From: Martyn White
Sent: 19 October 2018 09:30
To: Planning.Responses
Subject: A/126/18/PL

A/126/18/PL

PROJECT			
Scout Headquarters, Rectory Lane, Angmering, West Sussex			
DRAWING TITLE			
Existing & Proposed Plans			
CLIENT		DWG NO.	REVISION
1st Angmering Scout Group		18/01-01	
SCALE: 1:200, 1:500 @ A1		DATE: 15.08.18	DRAWN: ex

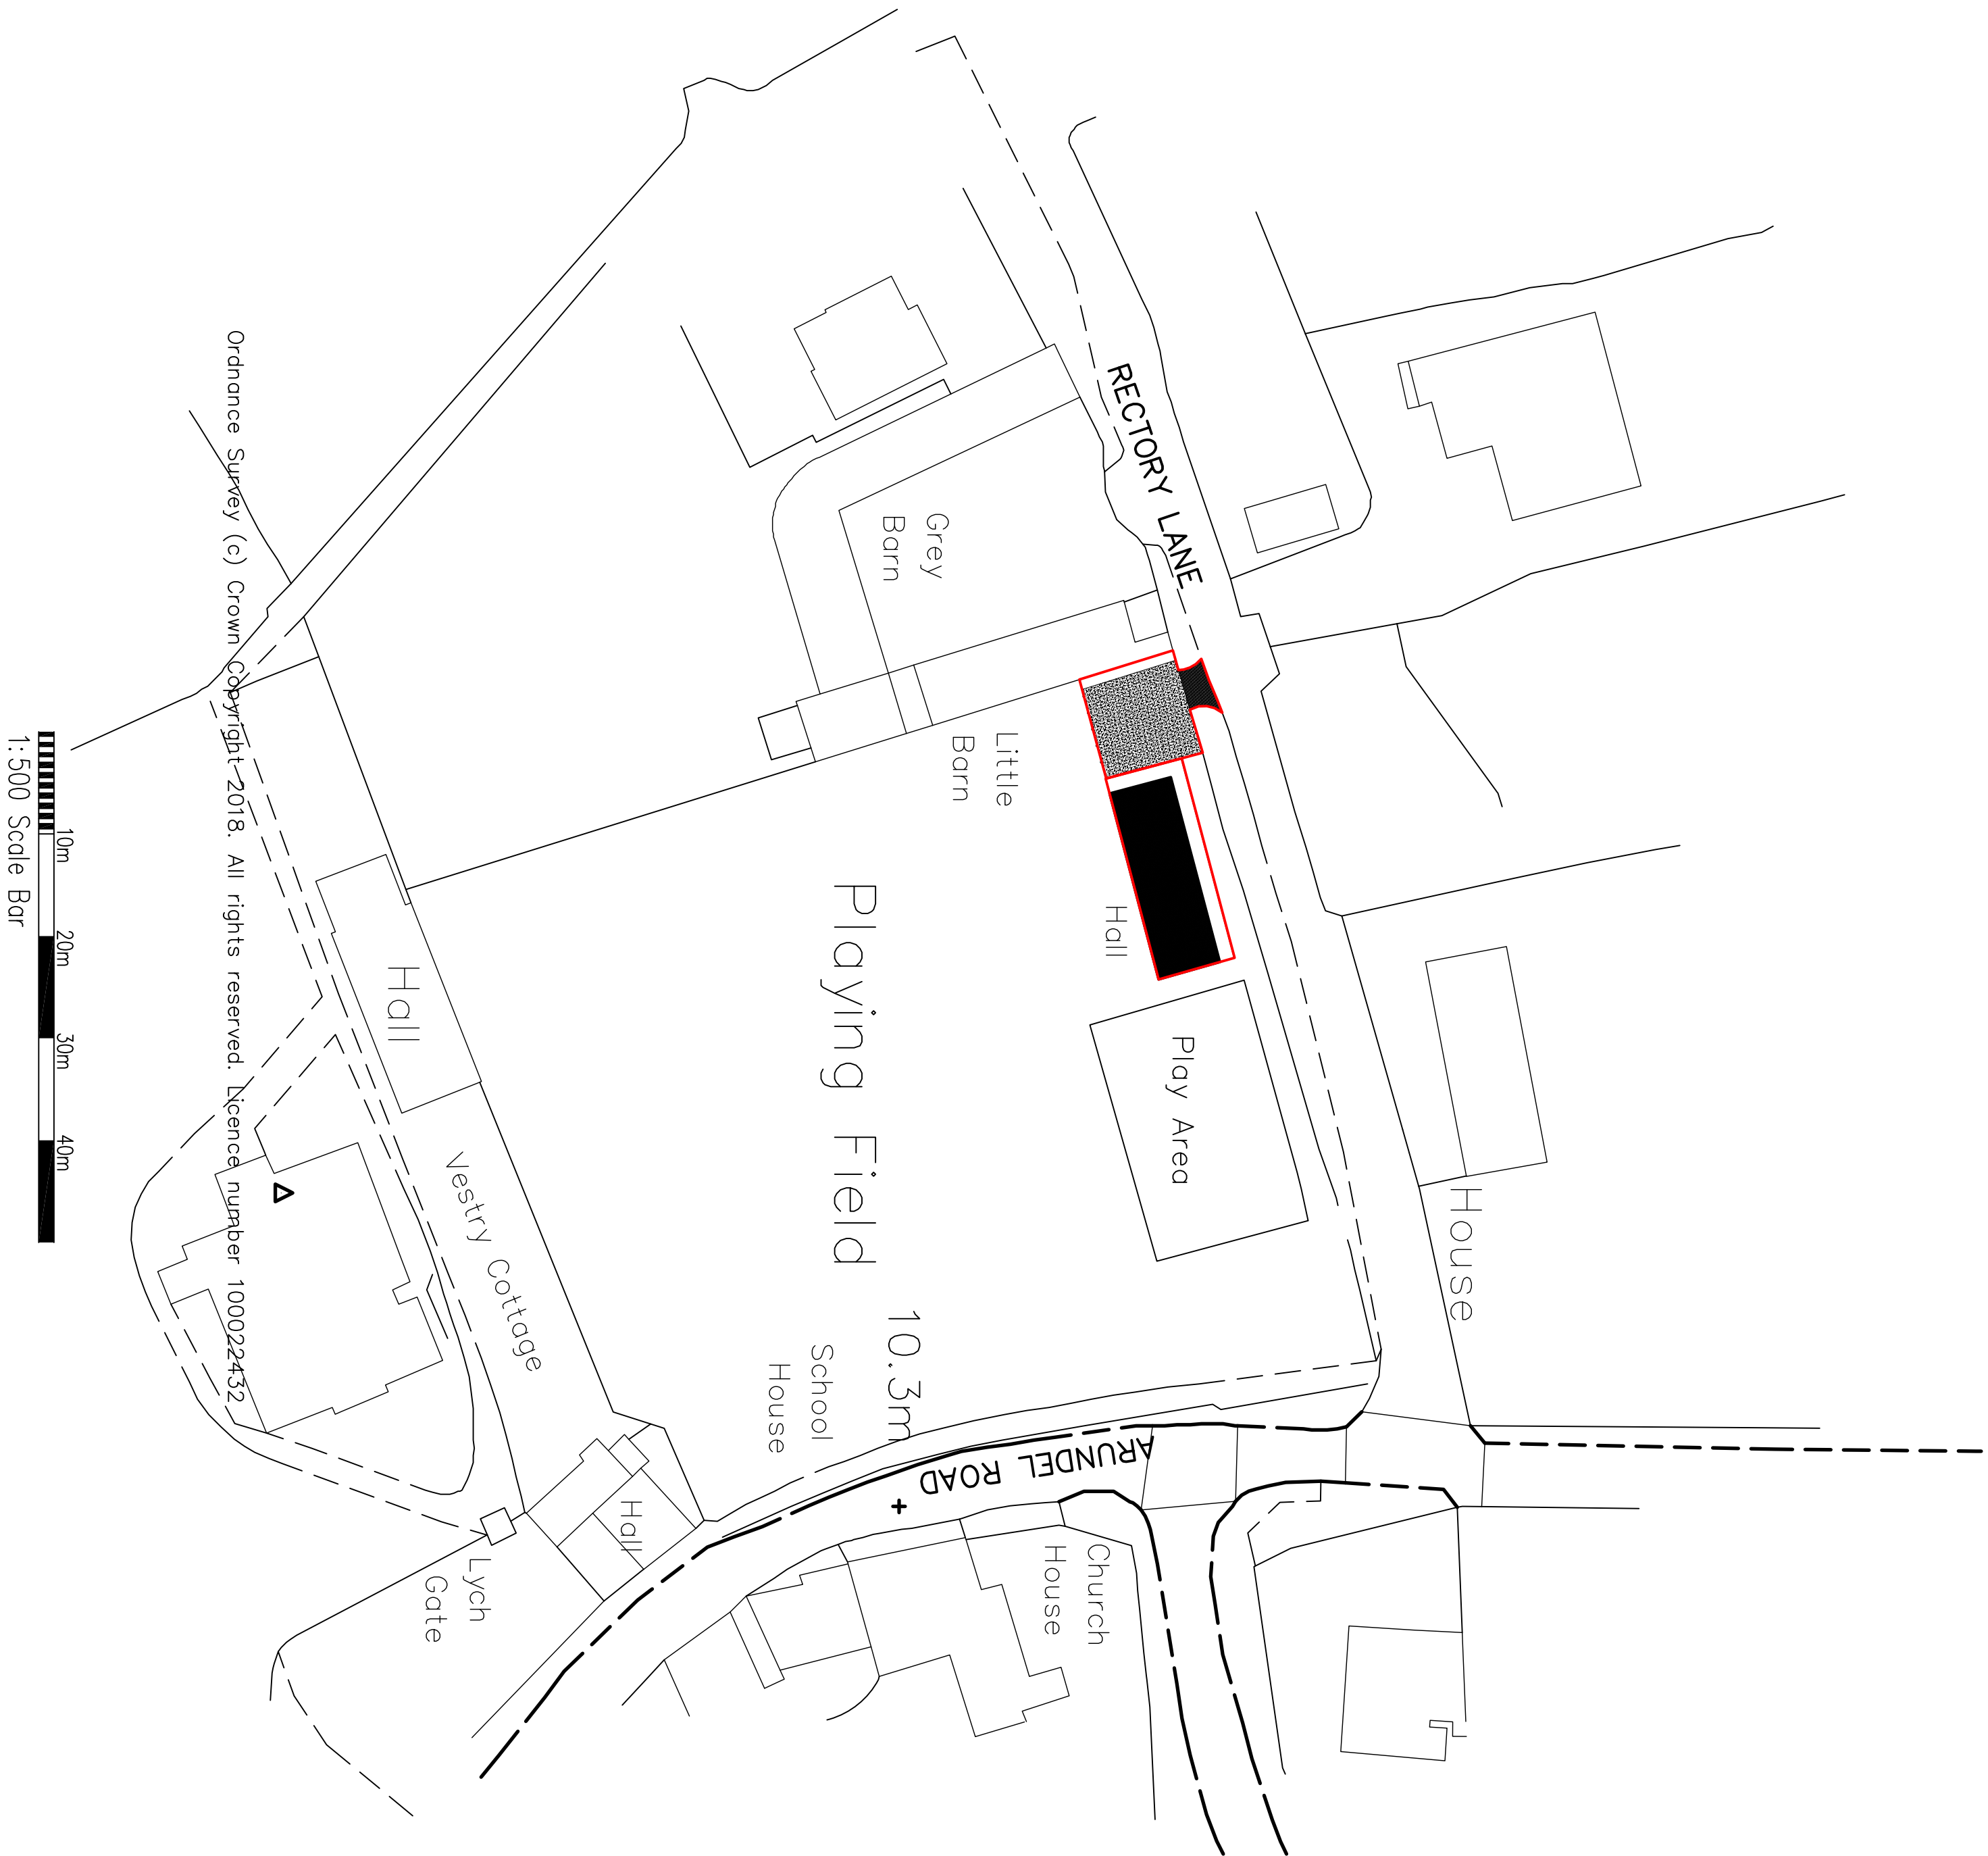
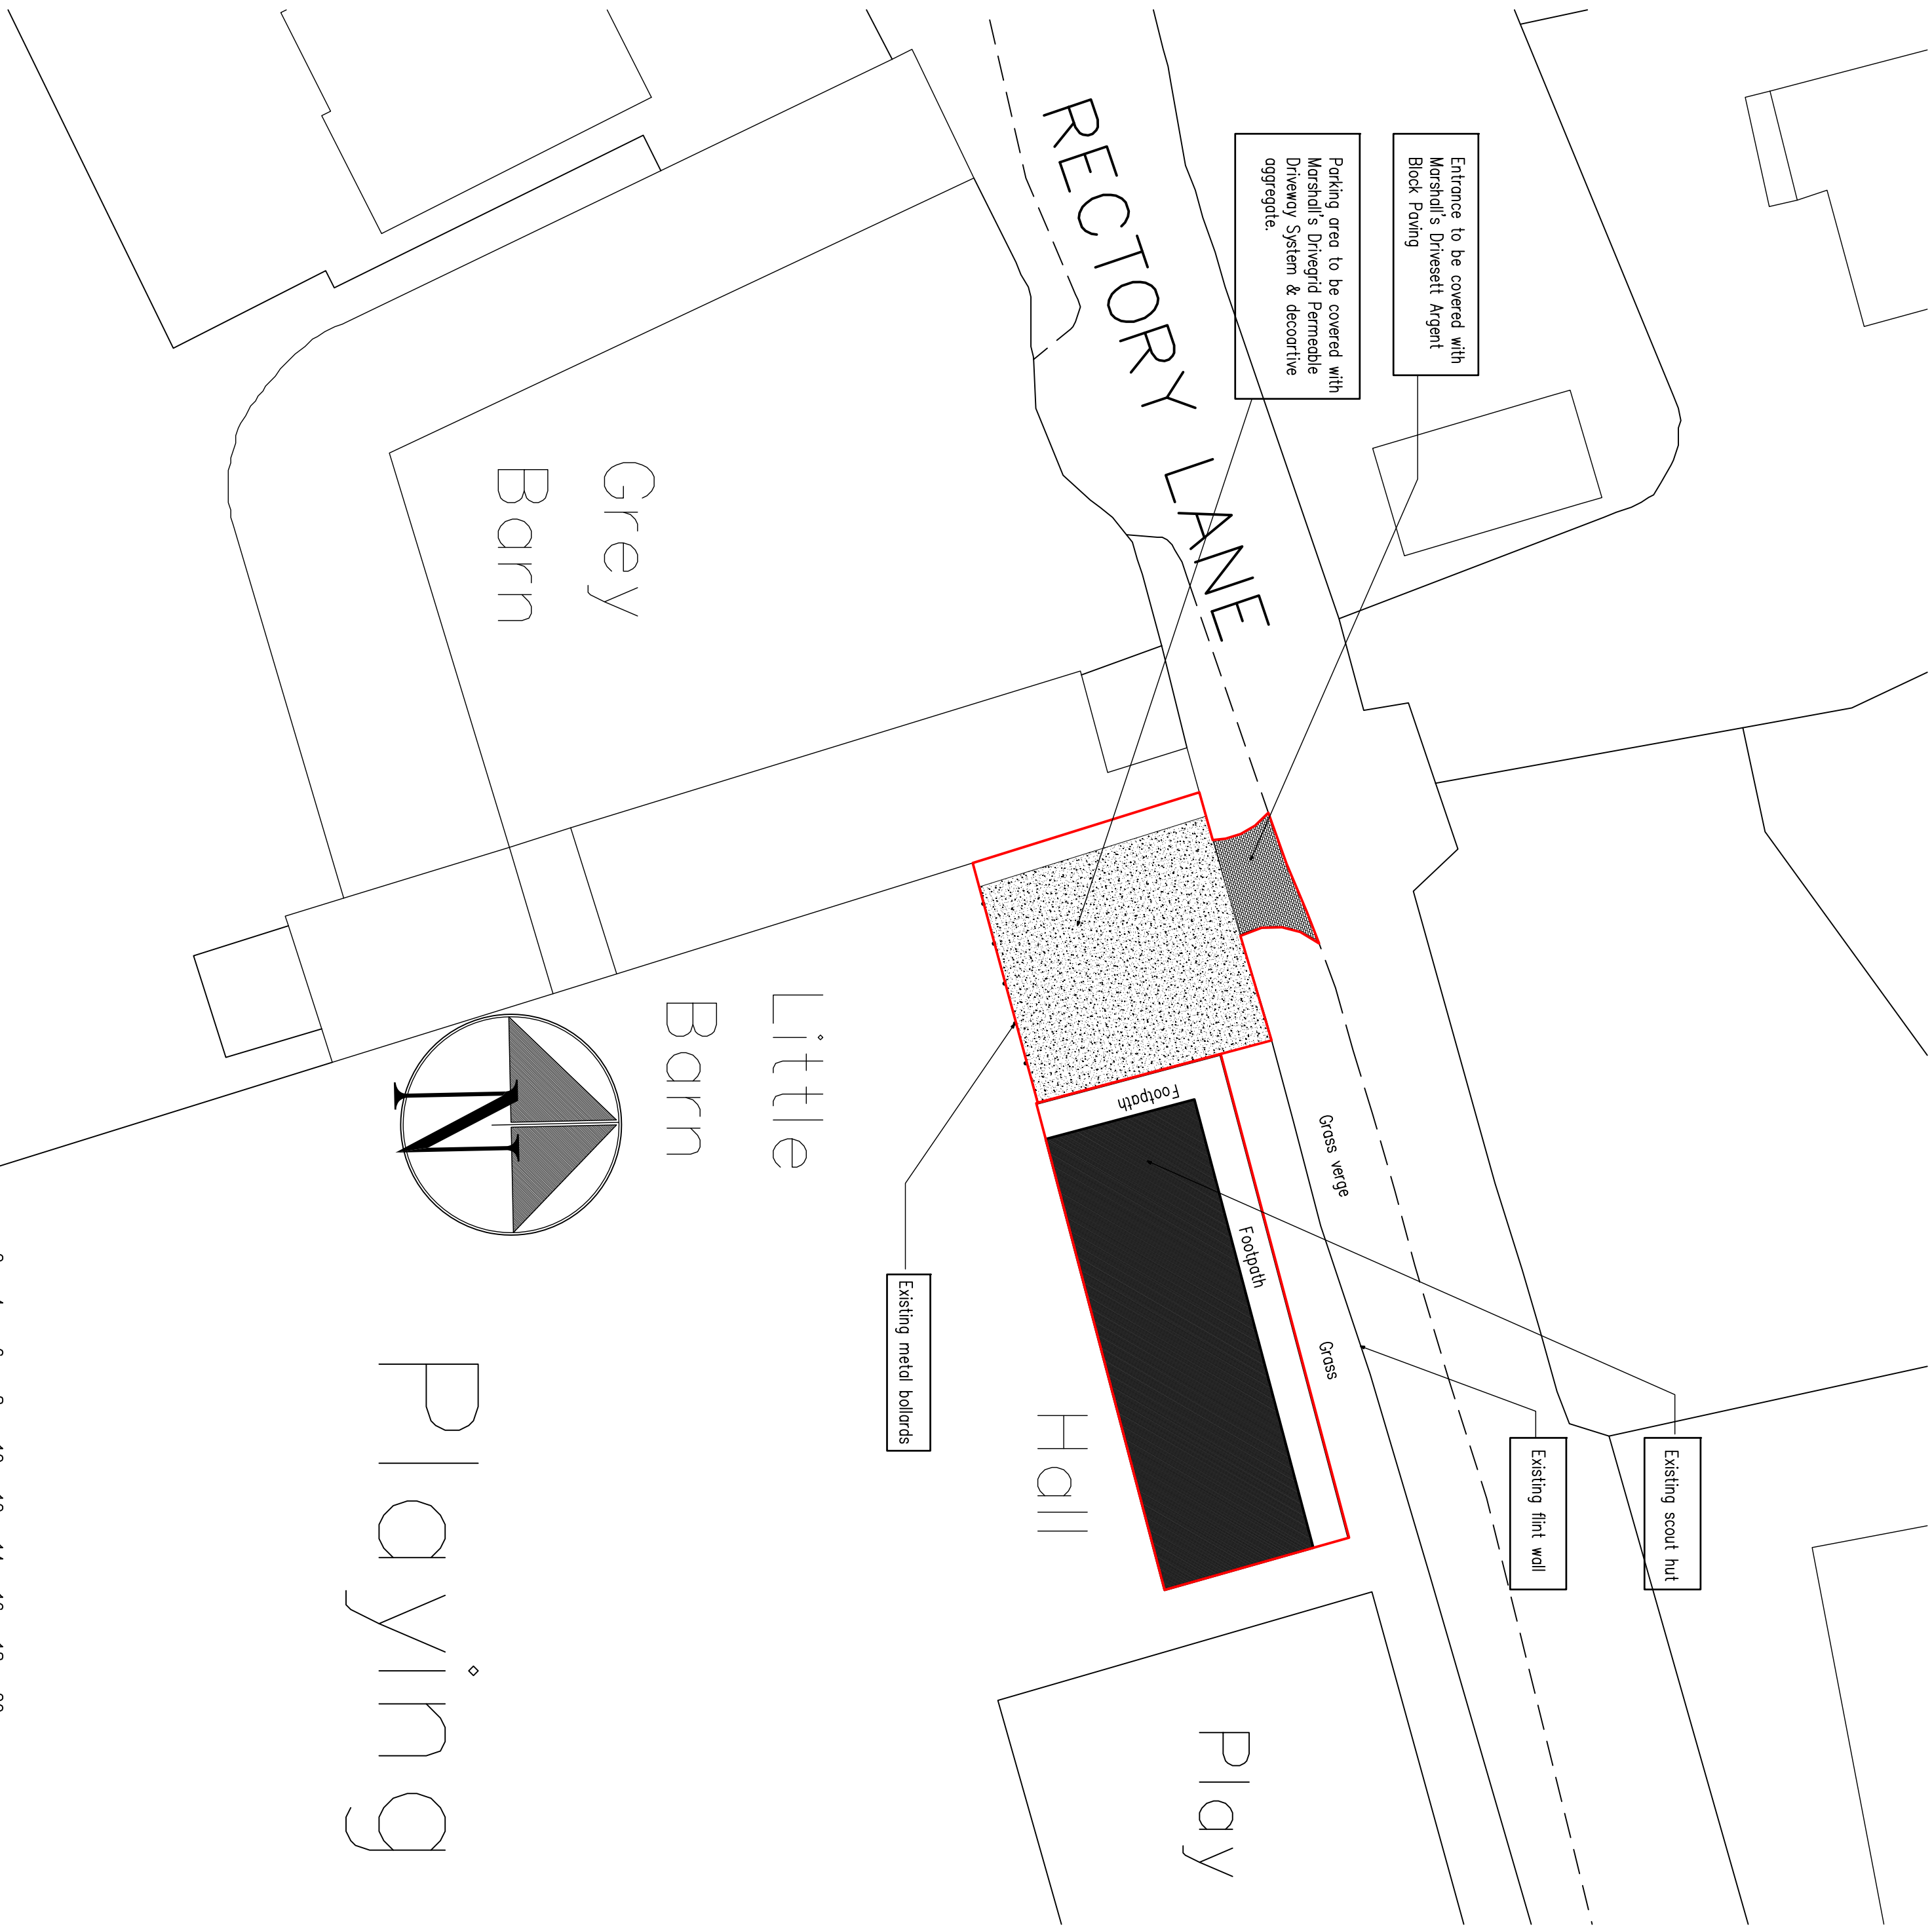
The proposal to introduce a more permanent surface material to the car park is considered to be acceptable as it will enhance the appearance of the area. It is therefore considered to be in accordance with policy HER DM3 of the adopted Arun Local Plan (2011-31).

However, it is not clear what colours the materials will be. This will need to be supplied to the council, but can be done by way of condition.
